***SECTION 96(1A) MODIFICATION APPLICATION
ASSESSMENT REPORT***

***Waterfront Promenade & Interim Public Domain
Works (SSD5374 MOD 1)***

Secretary's
Environmental Assessment Report
Modification of consent under section 96(1A) of the
Environmental Planning and Assessment Act, 1979

August 2015

# BARANGAROO | Promenade Section

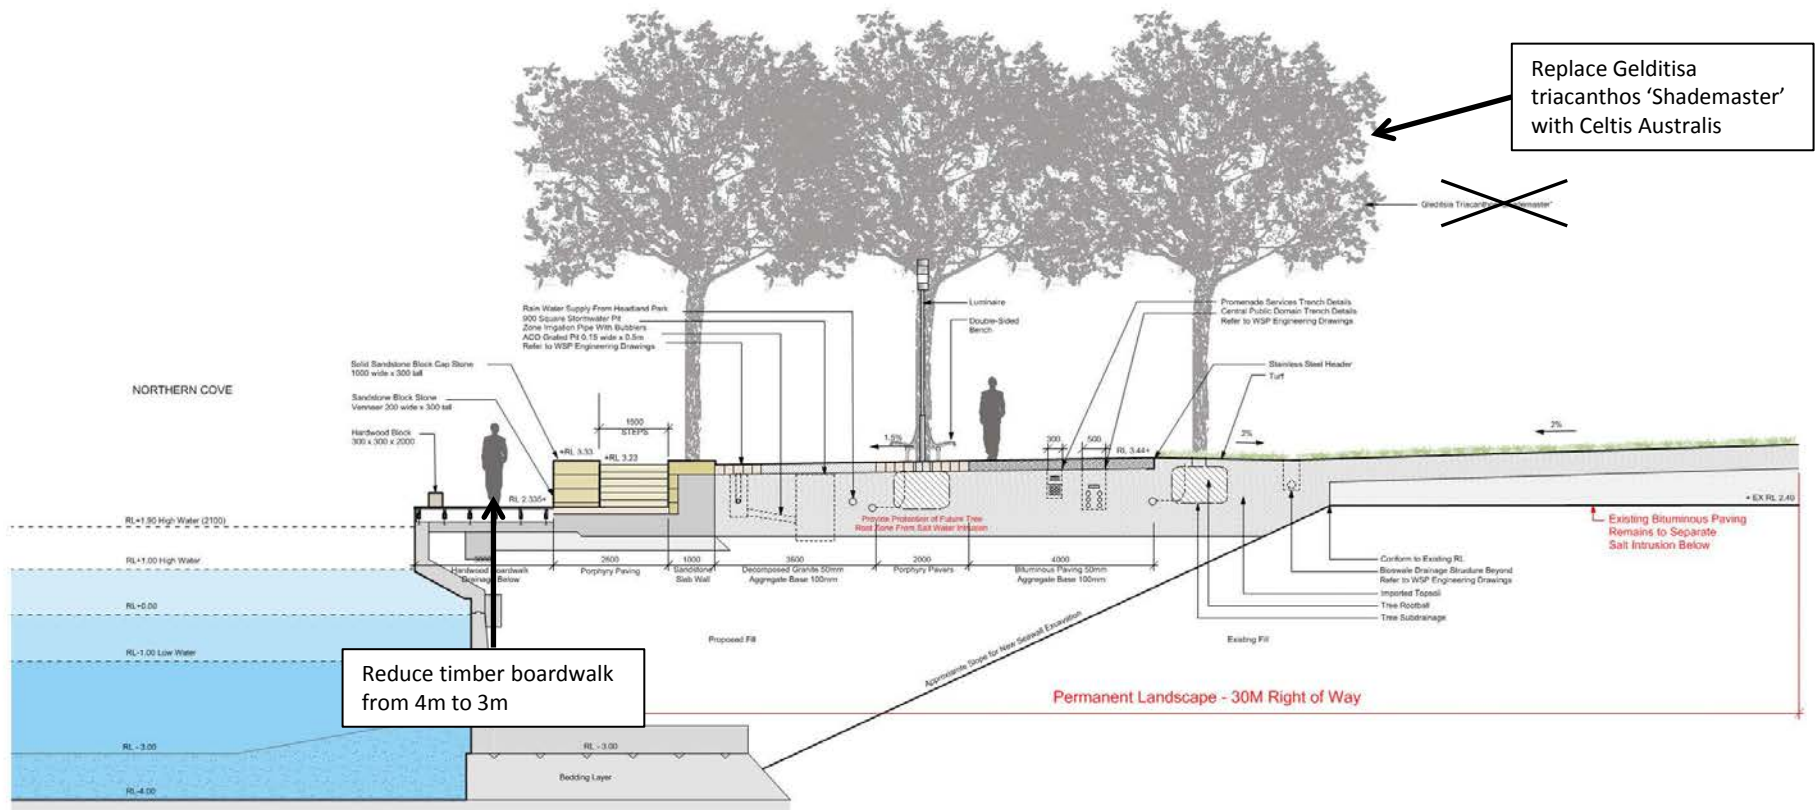
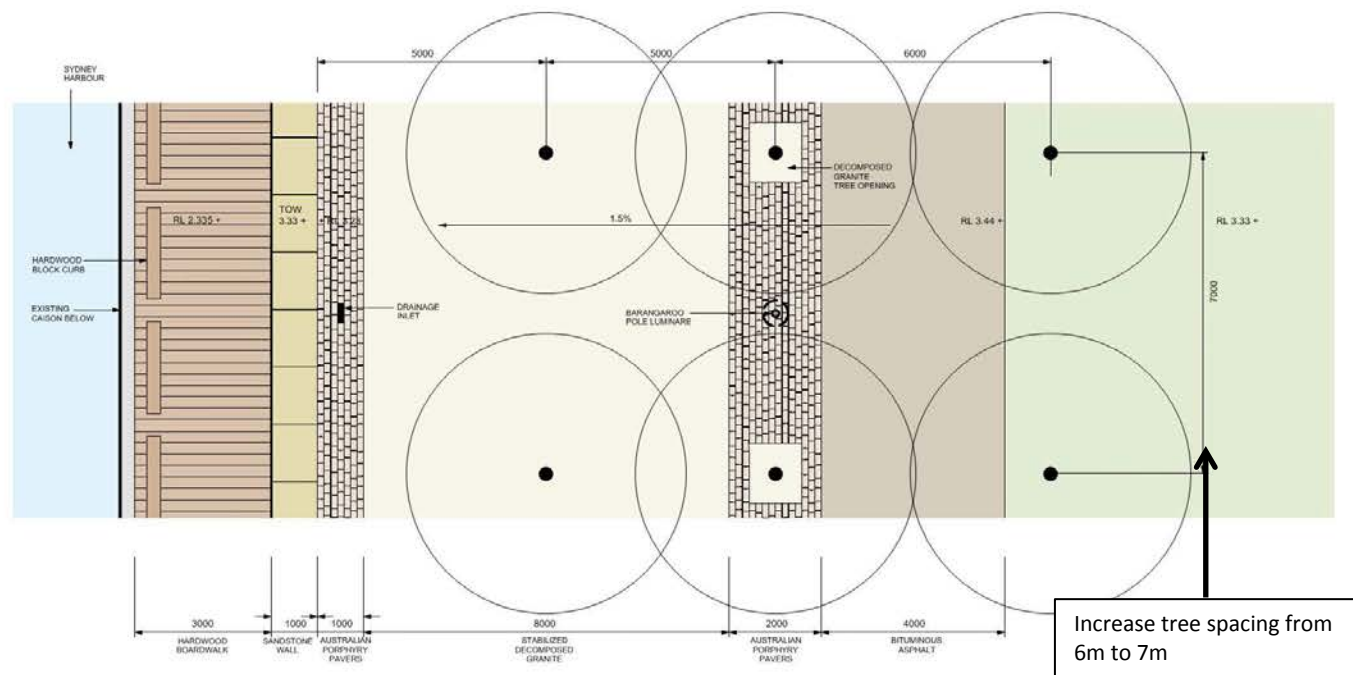
- The approved width of the boardwalk for Stage 1A of Barangaroo South is 4 metres and the width of the boardwalk for Stage 1B of Barangaroo South (including the Casino foreshore) is unknown. Further clarification is therefore requested to justify the reduction in the width of the boardwalk to 3 metres. Unless genuine justification can be provide, the reduction in width should not be supported.

- The reduced width will be problematic for a number of users. Although, the boardwalk is billed as a secondary path, it will nevertheless be highly attractive. The reduced width will also contribute to the walkway appearing out of scale with the sheer length of the waterfront.

- The reduced width of 3 metres does not reflect the true width available to users. The width will be further reduced to approximately 2.4 metres once obstacles like the proposed hardwood blocks are included. In the event that 3 metres is supported by the Department, the true width available to users should be 3 metres for the volume of users expected.

MOD 1 proposes to amend the design of the timber boardwalk by reducing its approved width from 4 metres to 3 metres. Given the design for the boardwalk retains the approved hardwood block edge to the water, this would mean that the effective width or usable surface of the boardwalk would be reduced from 3.4 metres to approximately 2.4 metres, as illustrated in **Figure 7** below.
